Recommendation Report for Planning Permission for Works or Extension to a Dwelling**REF NO:** EP/83/14/HH**LOCATION:** Middle Barn
The Street
East Preston**PROPOSAL:** New driveway and vehicular access to eastern boundary of property.
Resubmission following EP/143/13.**SITE AND SURROUNDINGS**

PROPOSED ELEVATION 1:100

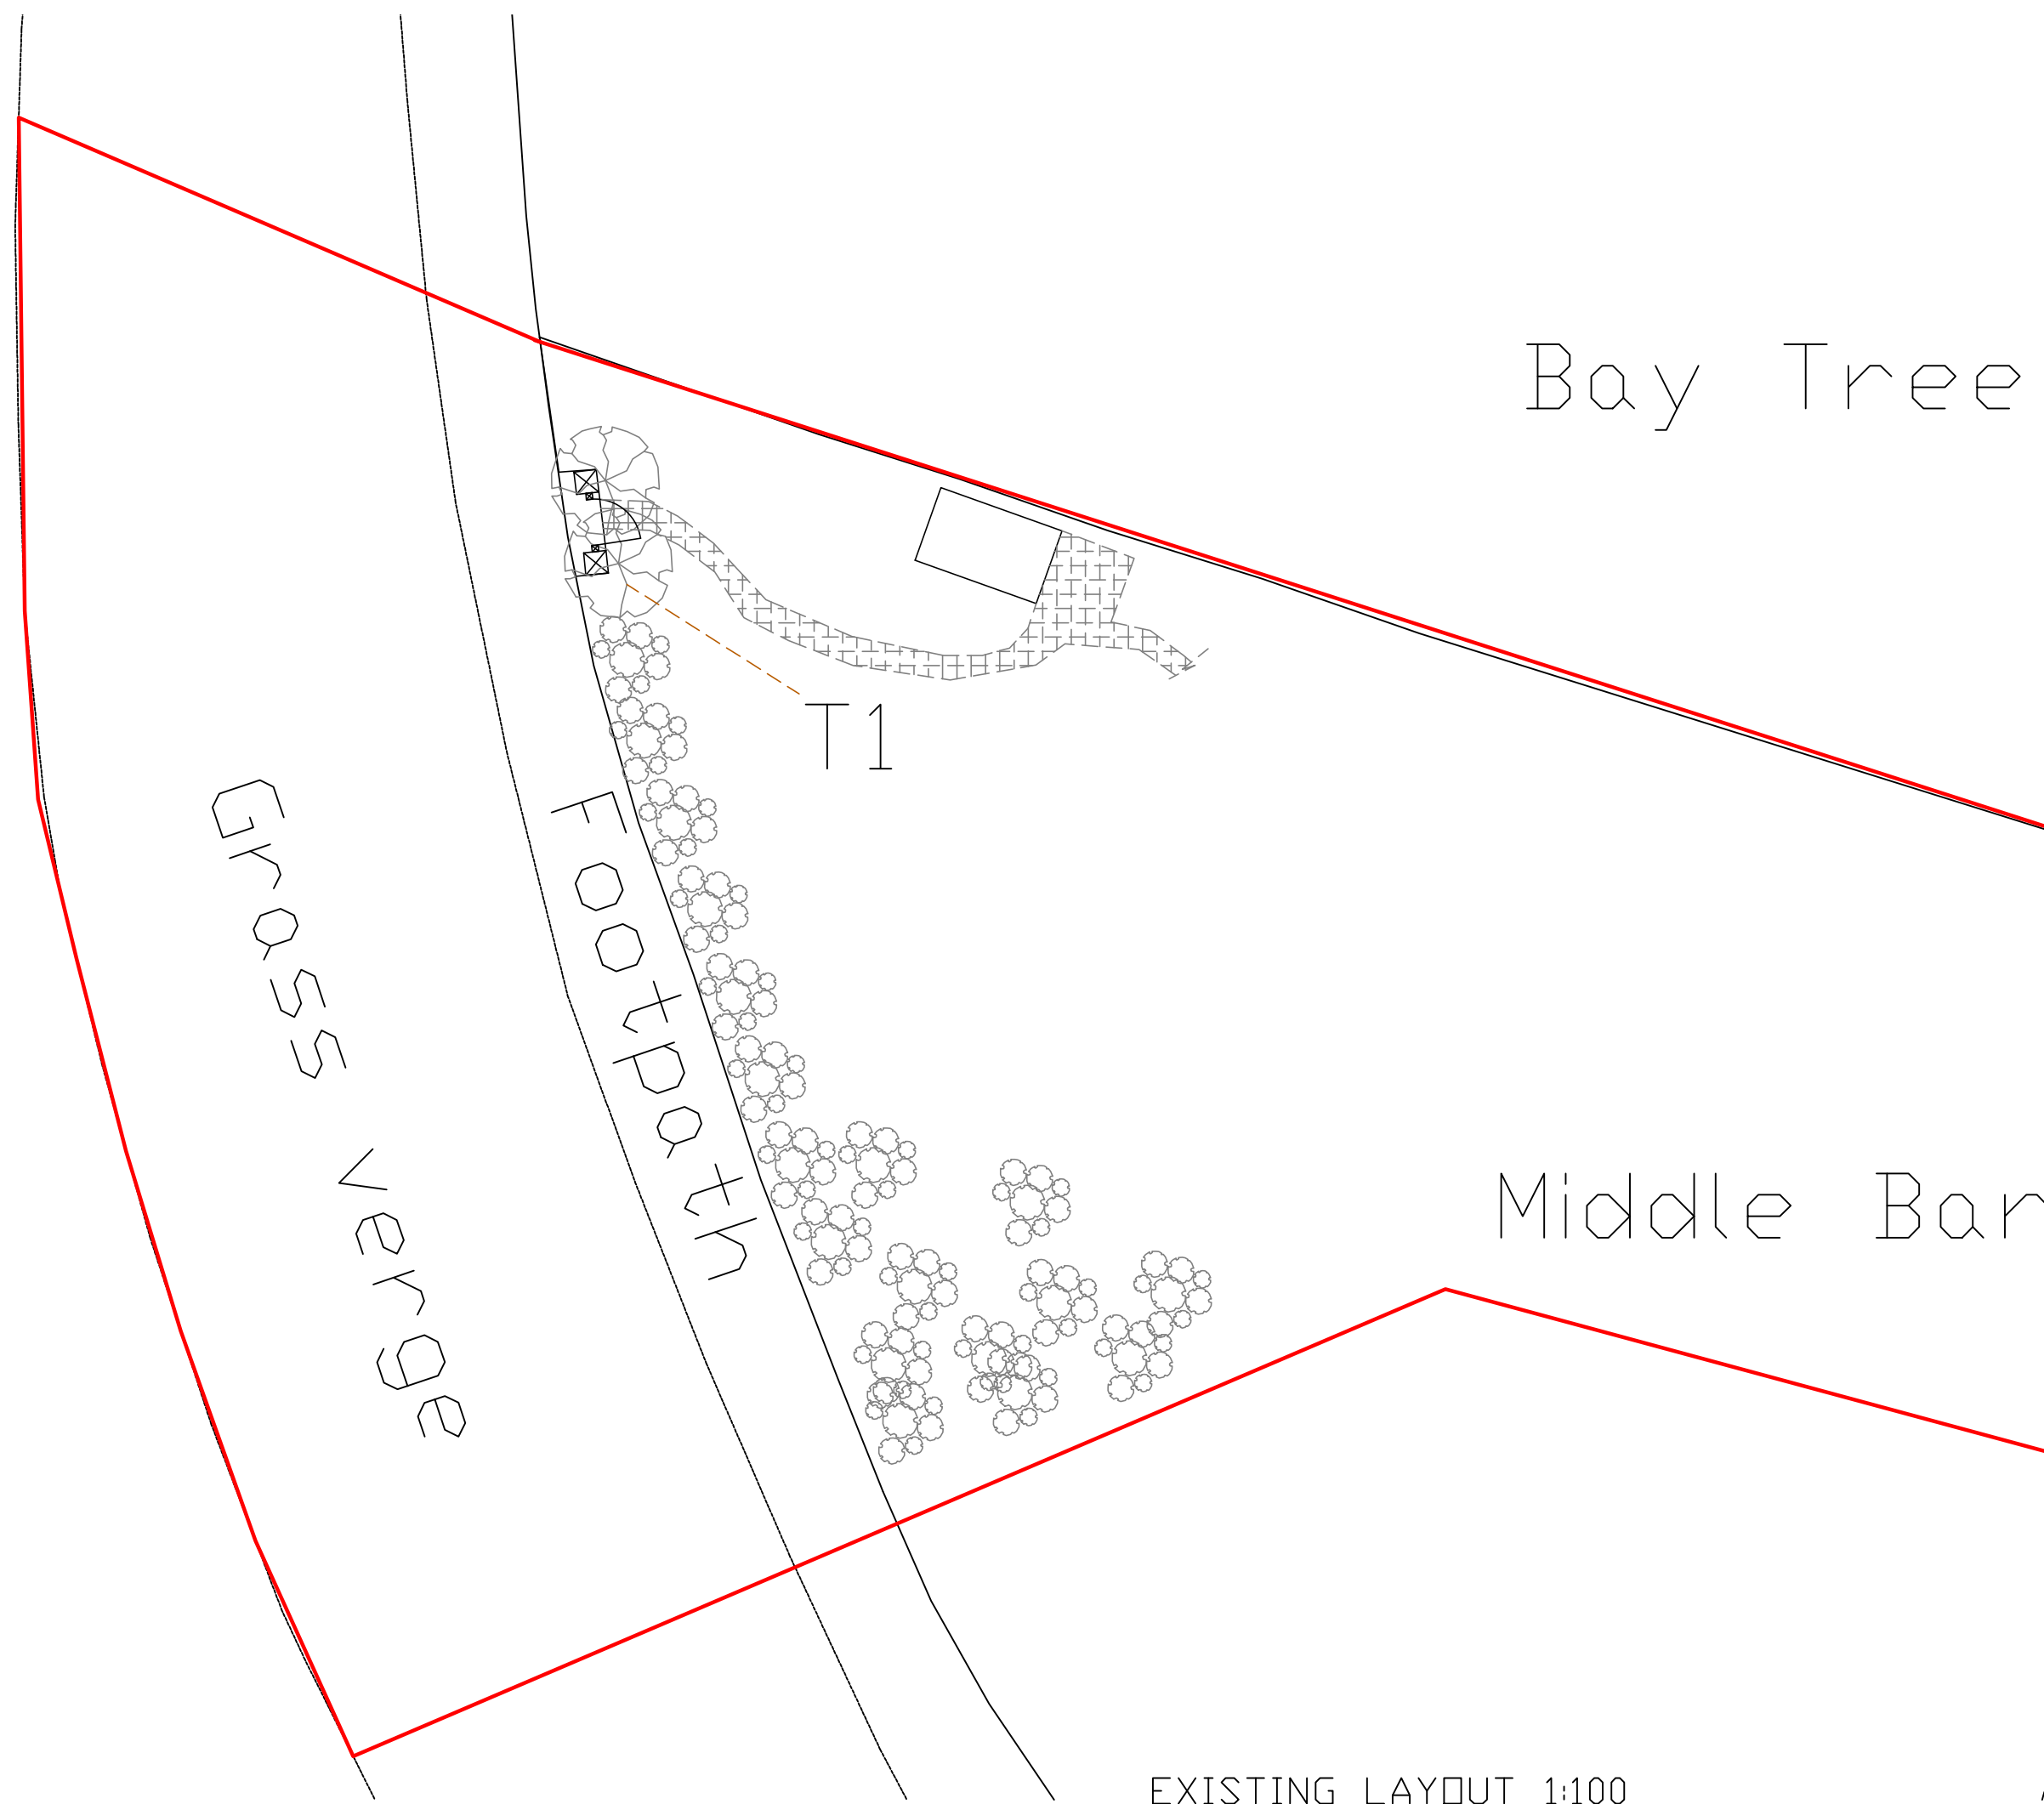
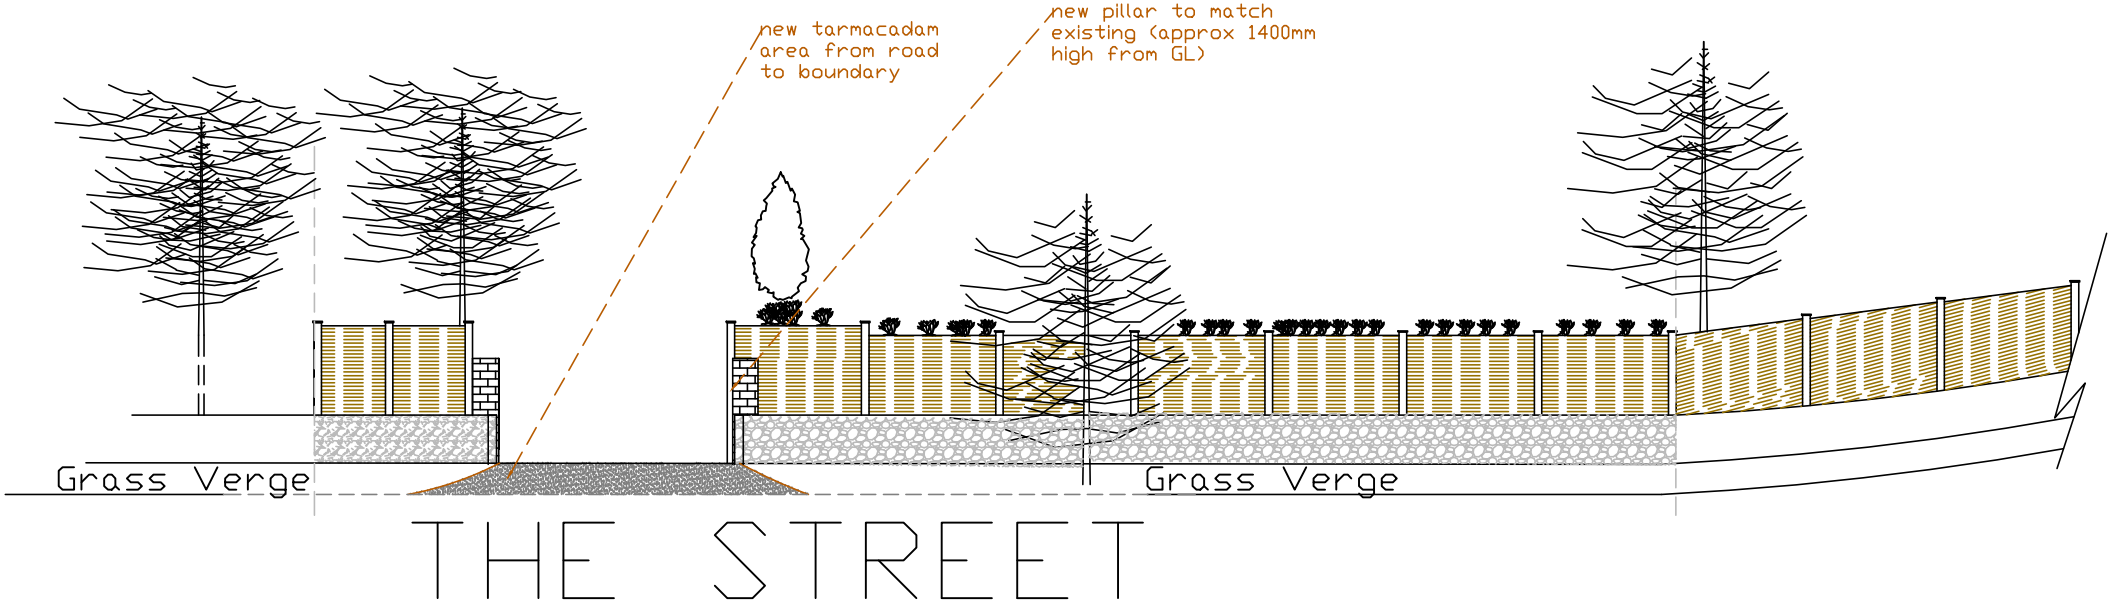
The proposal is approximately 30m away from Middle Barn and not raised off the ground to adversely affect this Building of Special Character in conformity with policy GEN22 of the Arun District Local Plan.

PROPOSED LAYOUT 1:100

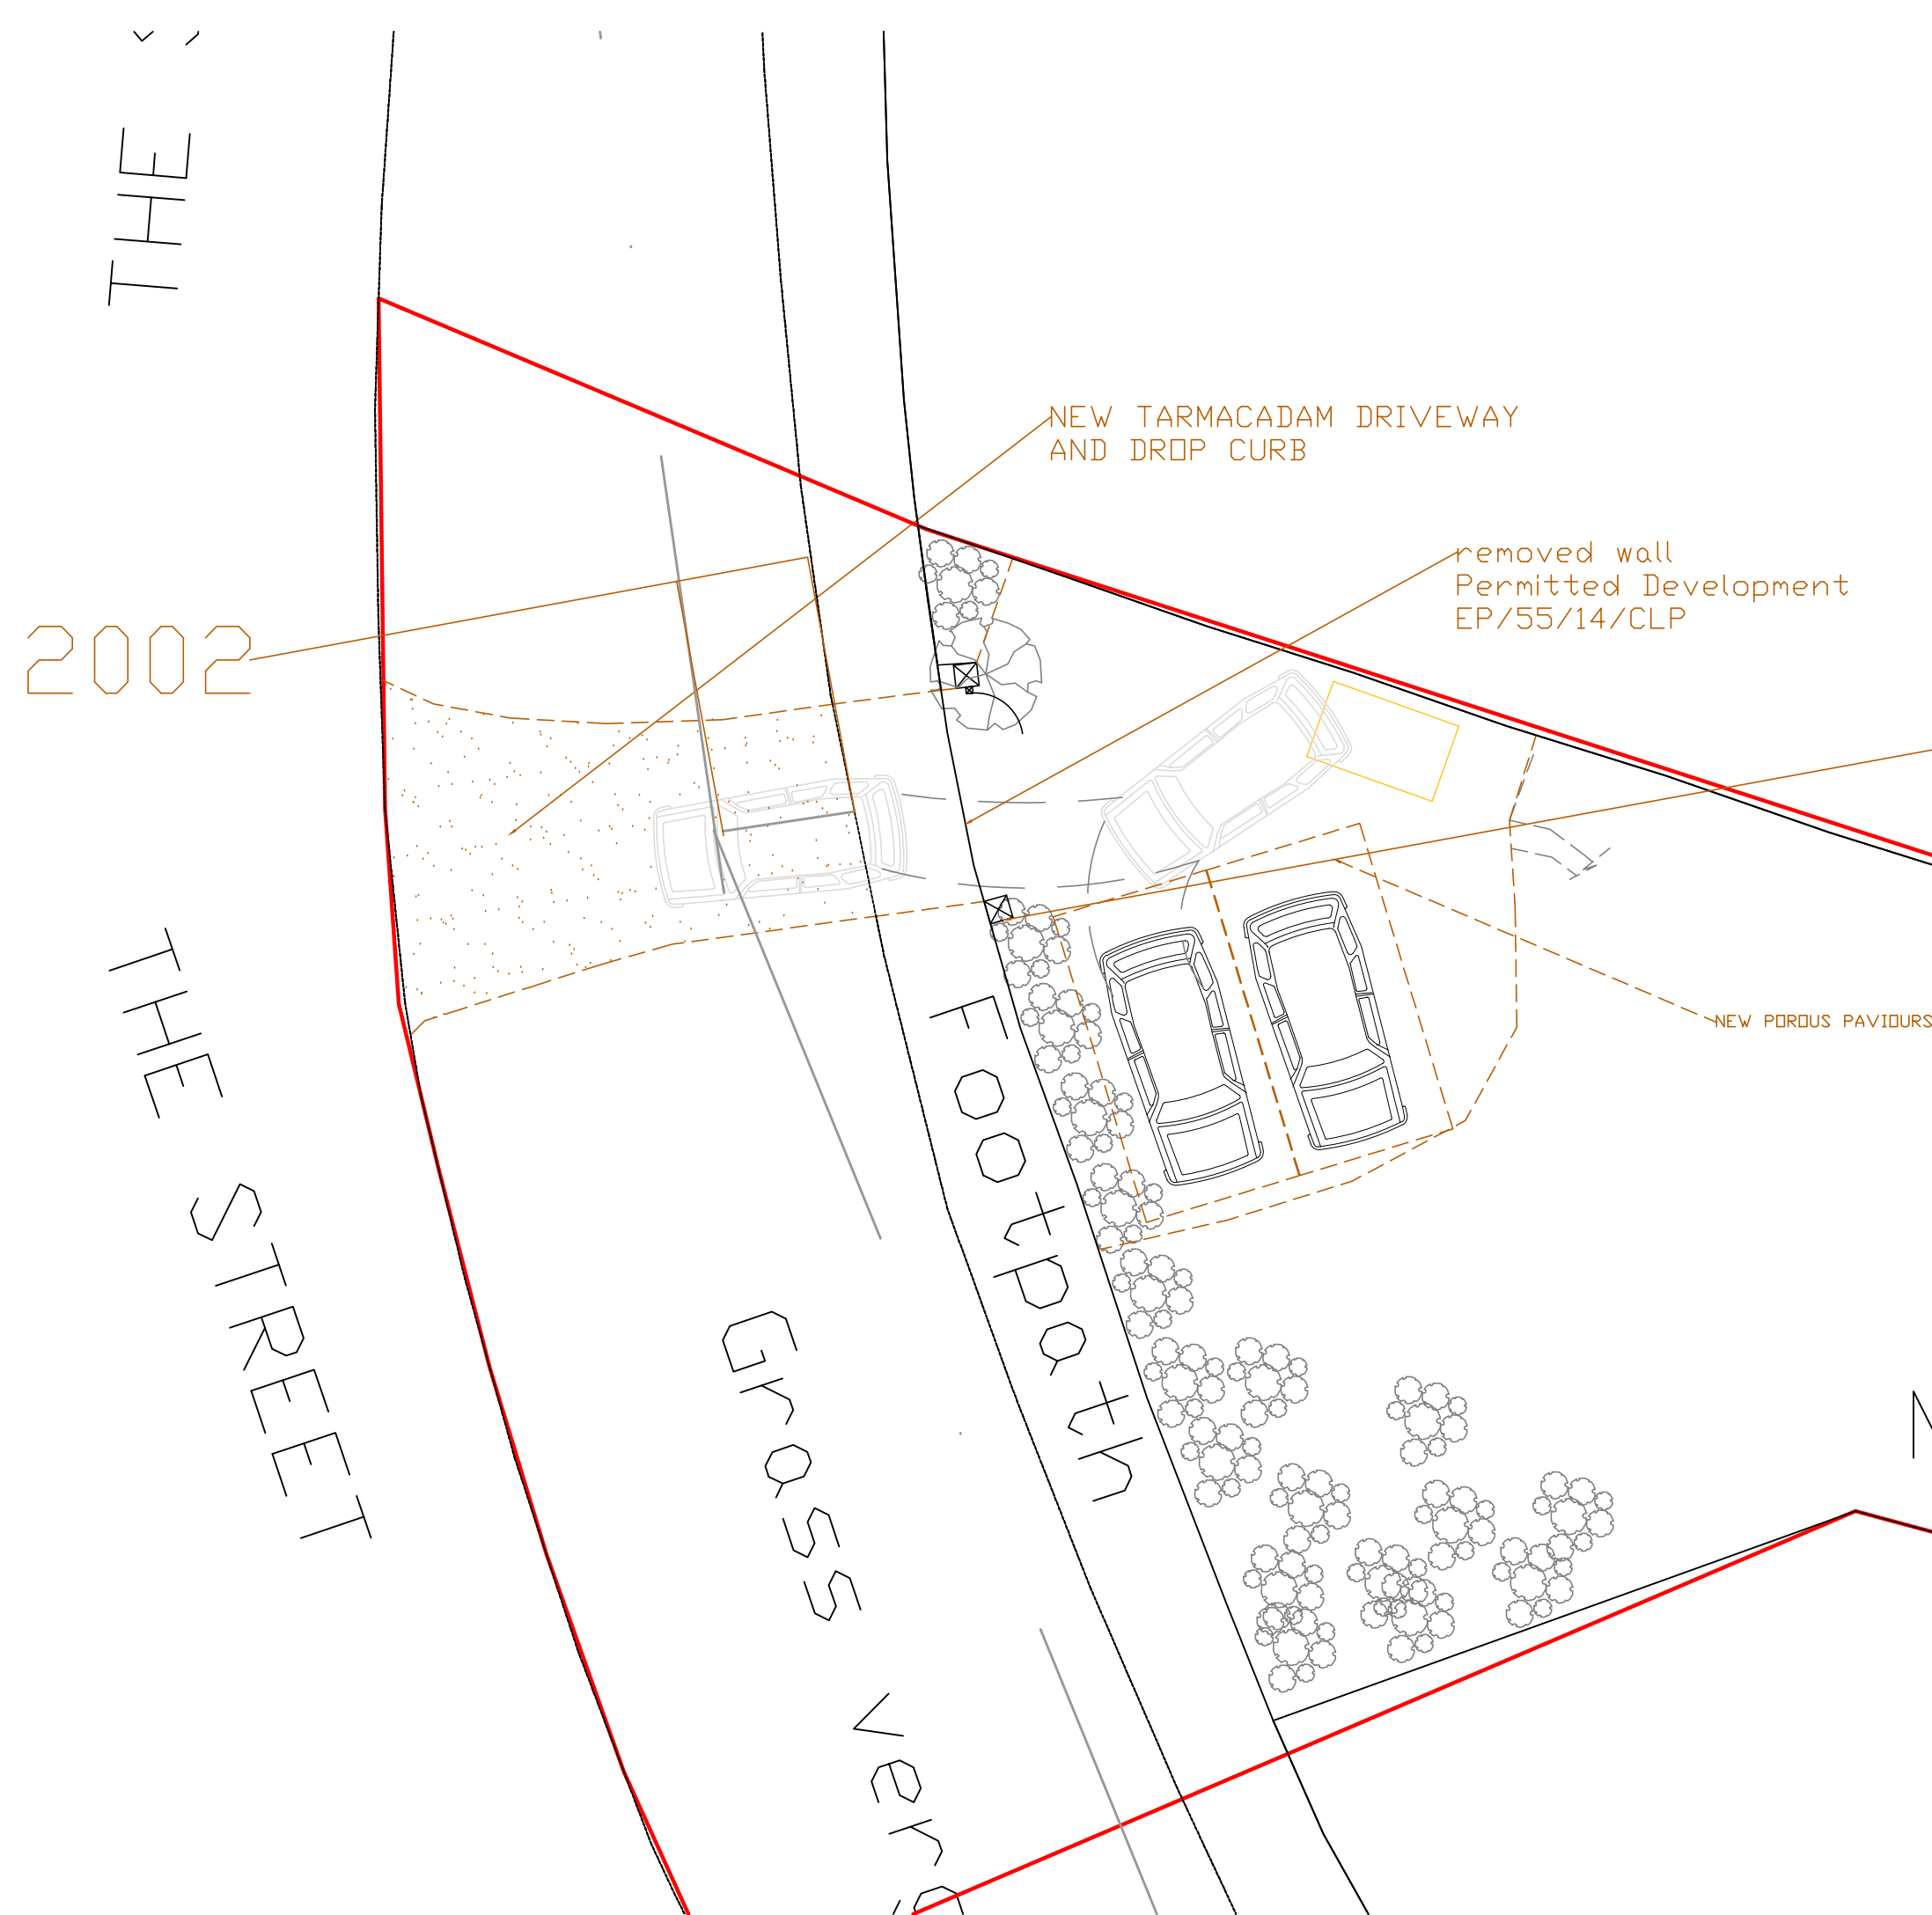
- Erosion of the grass verge within the village. The property is located within Character Area Three in the East Preston Village Design Statement and within this area, verges are reminders of the old village along roads must be preserved. It is therefore contrary to the village design statement.
- Middle Barn is on the Arun Buildings of Character (Local List) meaning planning permission should not be granted for an alteration that would adversely affect its appearance. The Committee feels a crossover may do just that and therefore should not be granted planning permission.
- The proposed location of the crossover would provide concerns about traffic exiting into The Street which is a busy road and a bus route.

Comments noted. In response, the proposed driveway in place of the grass verge will not cause any visual harm to the area due to its width of 5m which is comparatively small when set against the overall length of the grass verge at over 60m. Whilst the grass verge has special mention within Character Area Three of the East Preston Village Design Statement, the nature of the driveway with its limited profile will not be unduly prominent in the street scene. Given the limited amount of hard surfacing and the significant distance away from the host property, the proposal will not cause any unacceptable harm to the Building of Special Character. It will be similar in appearance to the existing driveway to the south particularly in its use of tarmac cutting across the grass verge. West Sussex County Council Highways department has no objection to the crossover from a highway safety perspective.

The proposed crossover will join on to The Street at a width of approximately 5.2m with a tarmac driveway in place of an existing grass verge. The driveway and dropped kerb will not cause any harm to visual amenity due to the limited profile of the driveway and the residential character of the road which this proposal is considered to be consistent with. It will also be similar in appearance to the existing vehicular access to the south which also comprises of tarmac that bisects the grass verge. As well as this area of tarmac the nearby properties enjoy paved crossovers and the proposal will not be out of keeping.

Whilst the grass verge is mentioned in Character Area Three of the East Preston Village Design Statement, this is not considered sufficient justification to retain the grass verge against a

- 3 No works shall commence until details have been submitted to and approved by the Local Planning Authority for the drainage measures and materials used in the construction of the crossover and hardstanding area and shall thereafter be implemented and retained in perpetuity.
